CITY OF ALBUQUERQUE

July 23, 2014

**Re: Hedges Residence
Grading and Drainage Plan
Engineer's Stamp Date 4-22-14 (E22D007F7A)**

GRADING & DRAINAGE PLAN

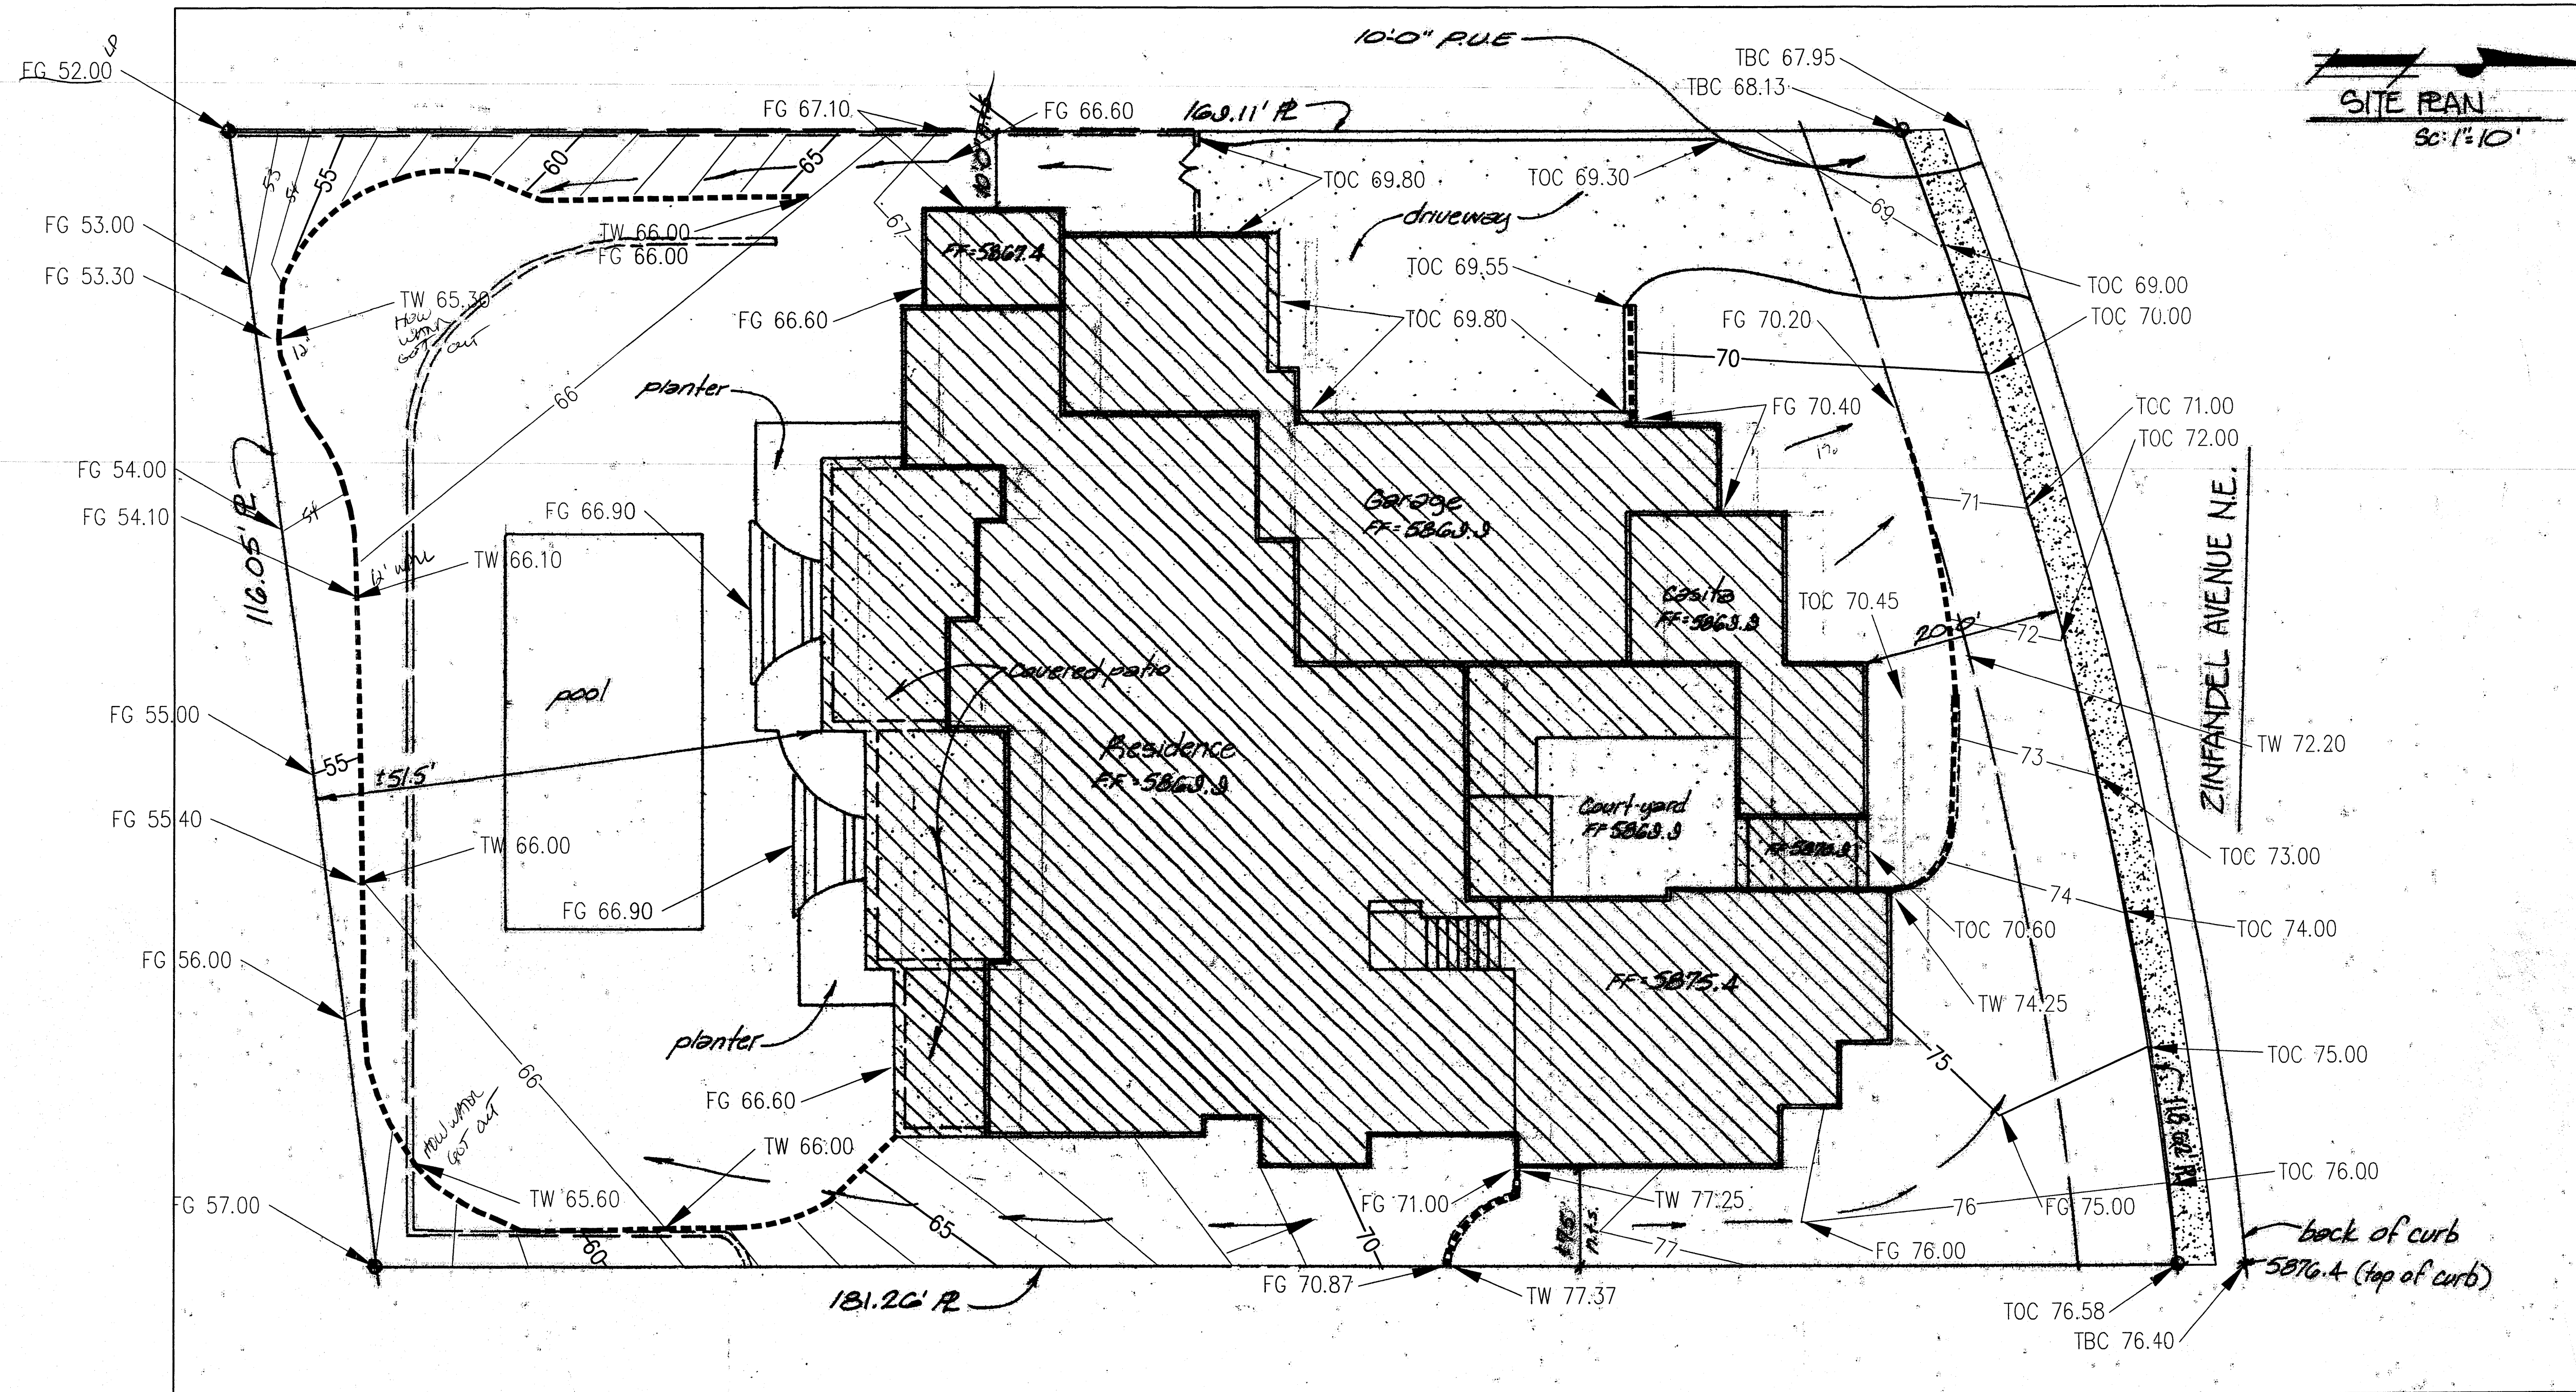
1. Provide a fully completed Drainage and Transportation Information Sheet.
2. Provide calculations for existing and proposed flows that are in accordance with the approved Master Drainage Plan for the Sauvignon Phase II Subdivision by Bohannon Huston, Inc. Provide excerpts (plans and calculations) from the MDP that pertain to this property. Indicate how the grading design of the property is in accordance with the MDP. Indicate all your existing and proposed design assumptions including ones for land treatments and hydrology and provide all calculations with full explanation.

3. Provide a Grading and Drainage Plan with the following:
 - Existing and proposed contours and spot elevations on-site and to 20 feet off-site. Fully show that existing grades along the perimeter are being met with the proposed design.

- Show all aspects of the plan to scale.
 - Provide a vicinity map and FIRM map.
 - Include the legal description and benchmark.
4. What are flow line elevations in Zinfandel? Does the driveway create a water block to prevent street flows from entering the property?

5. Wherever there are top of wall elevations, provide top of grade elevations in the same location.
6. A 12 foot wall is on the south side. Is the top of wall actually the top of wall or top of the retaining wall? A garden wall on top of that is advisable since a twelve foot drop is there. If a garden wall is on top of that, how will the wall drain out? Provide calculations for the opening and erosion protection. What protection will be at the bottom of the wall to prevent erosion?

7. Along the sides of the property, swales with erosion protection should be provided so the water does not enter the adjoining side properties or flood soil along walls.

8. On the east side of the residence, steep grades are dropping from the home. This seems impractical if someone needs to walk around the perimeter of the residence.

9. What are the elevations around the pool? No drainage should be entering the pool. A double dashed line is shown on the south side of the property but not described in the legend. What does that represent?

10. Retain the first flush. Per the City Drainage ordinance, the 90th Percentile Storm Event, which is 44 inches, is to be managed. Reduce 0.44 inch by the 0.1 inch for the initial impervious abstraction in Table A-6 of Section 22 of the DPM. Multiply the remaining 0.34 inch by your impervious area. This is the portion to retain.
